Our ref: Hastings Secondary College Port Macquarie Campus Upgrade Modification 1
(SSD-11920082-Mod-1)

17 August 2022

Subject: Response to Submissions

title
General Arrangement Plans
General Arrangement Plan - CAPA & New Link Roof Plan

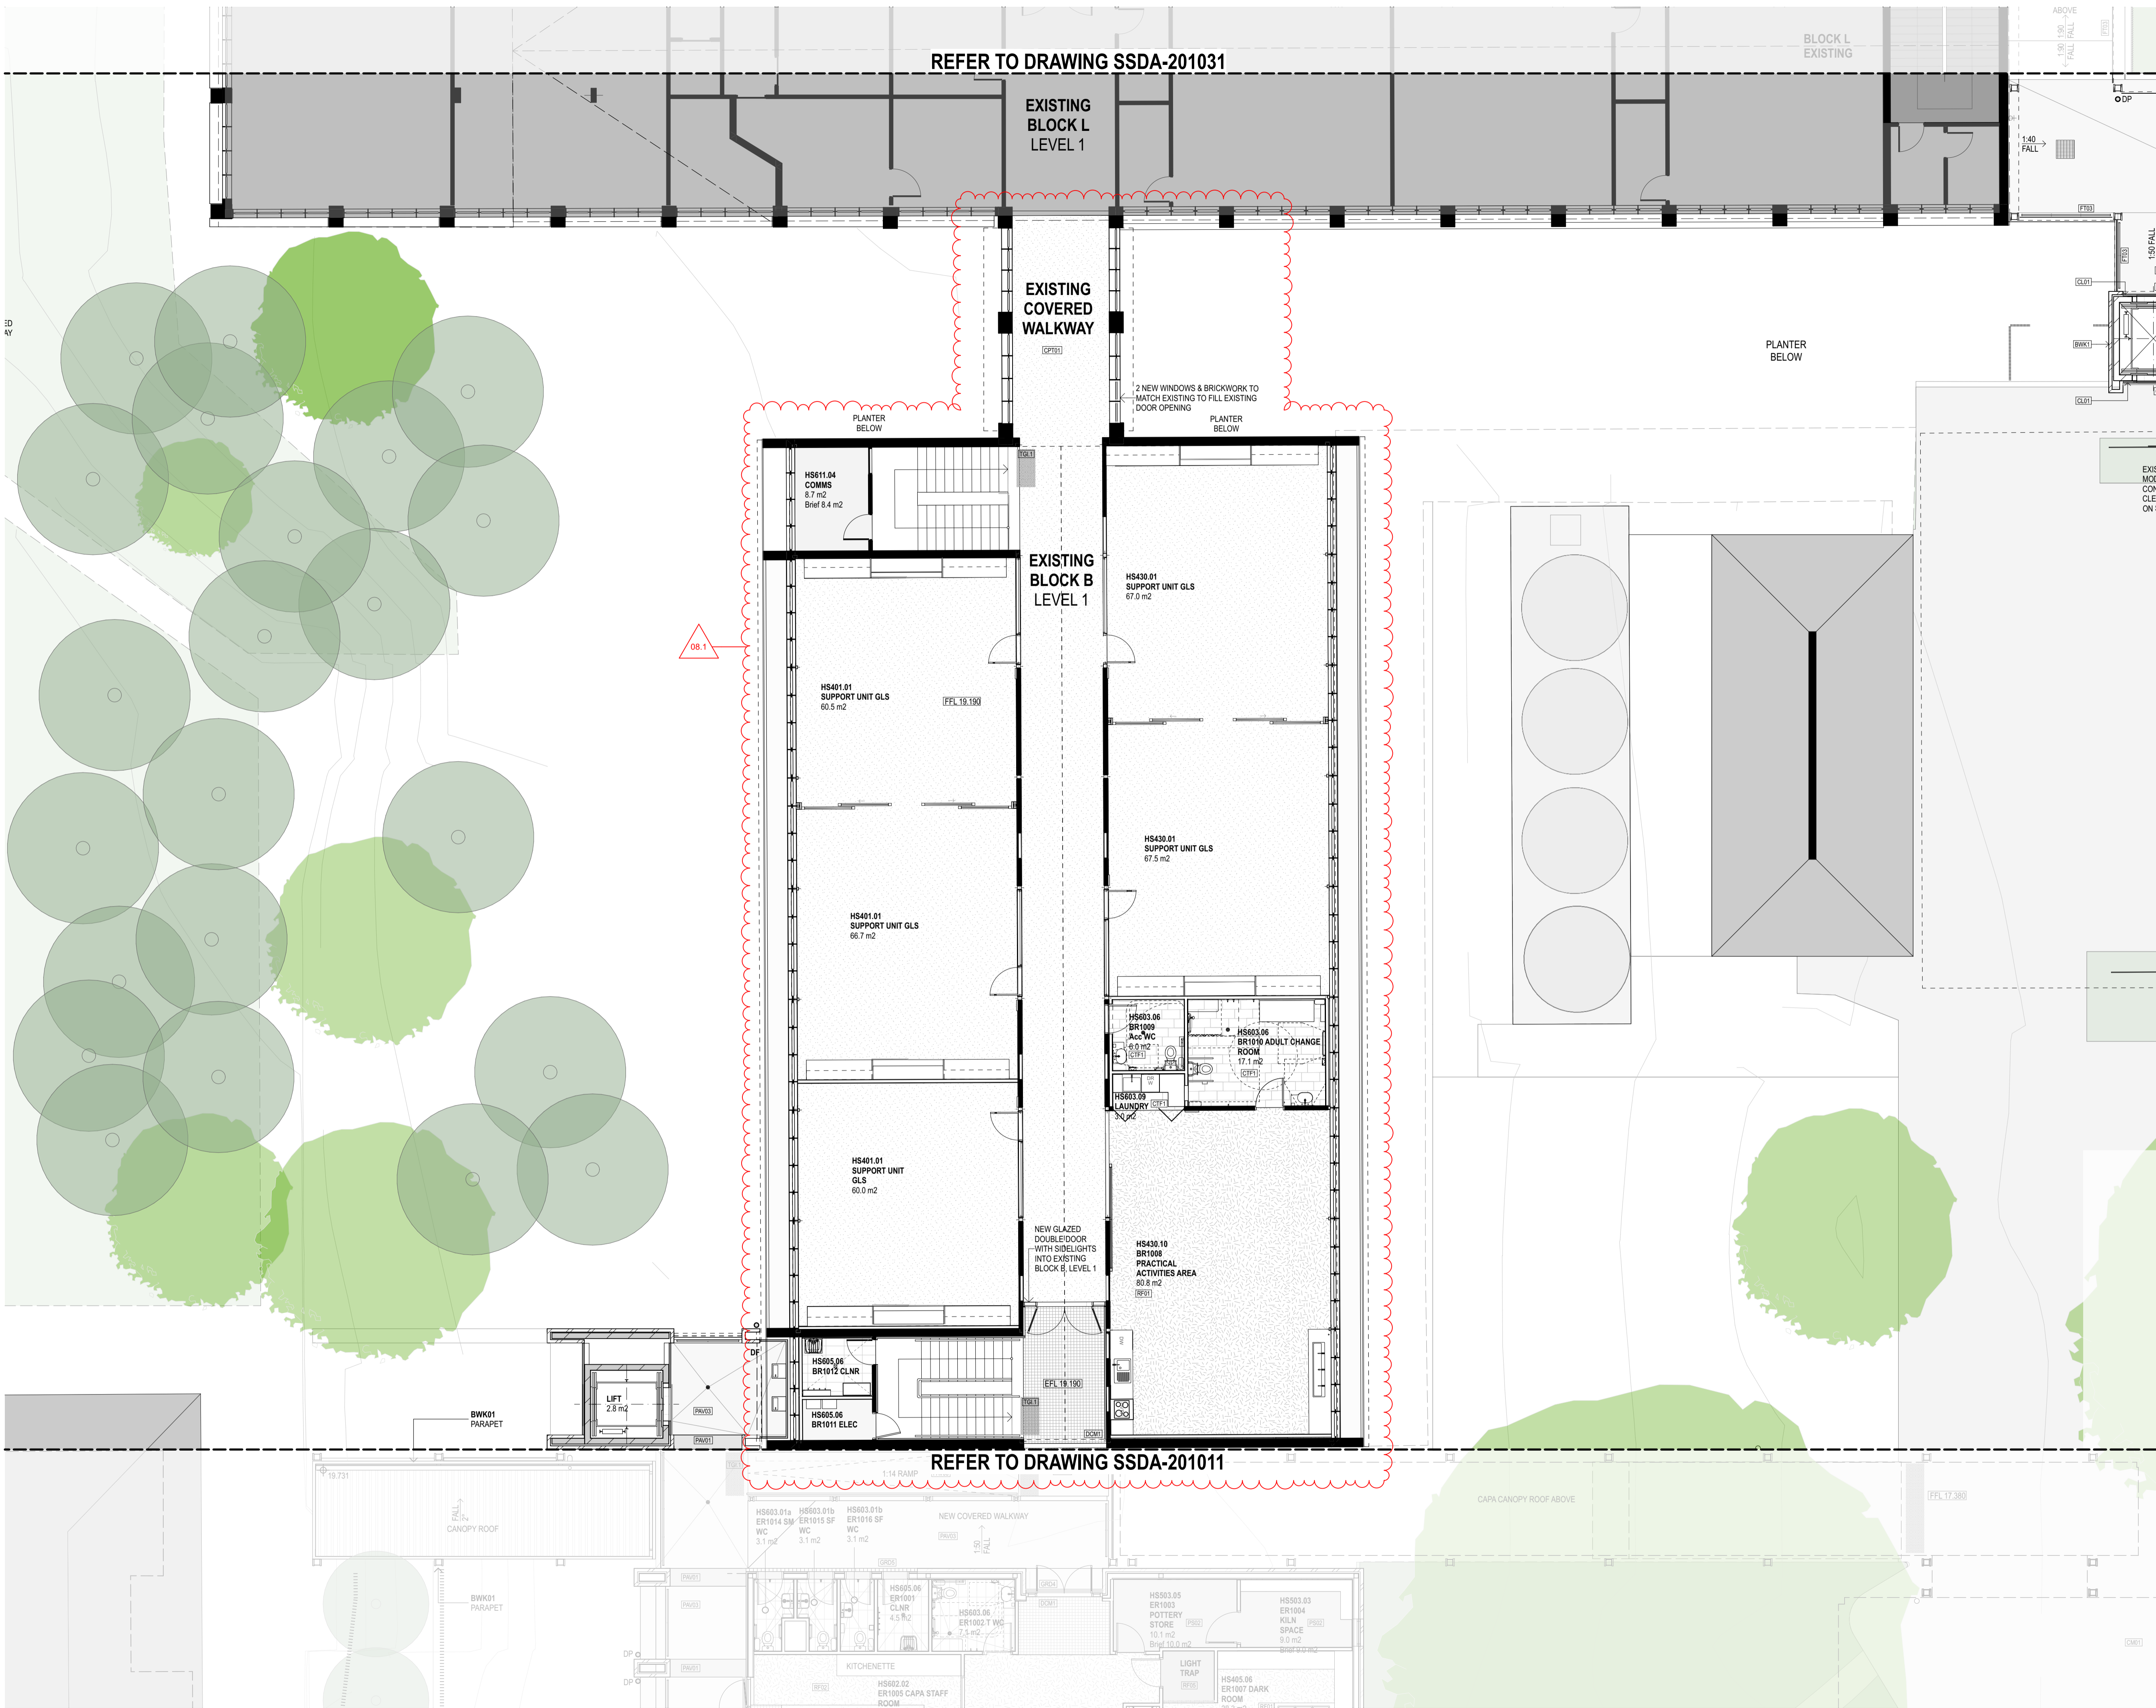
- Public submissions raised concerns about impacts of the rooftop mechanical plant above the CAPA Building to private views. An updated Visual Impact Assessment of impacts to views from the private domain must be provided that appropriately assesses the impacts of the proposed modification having regard to the applicable planning principle (i.e. Tenacity Consulting v Warringah Council [2004] NSWLEC 140).
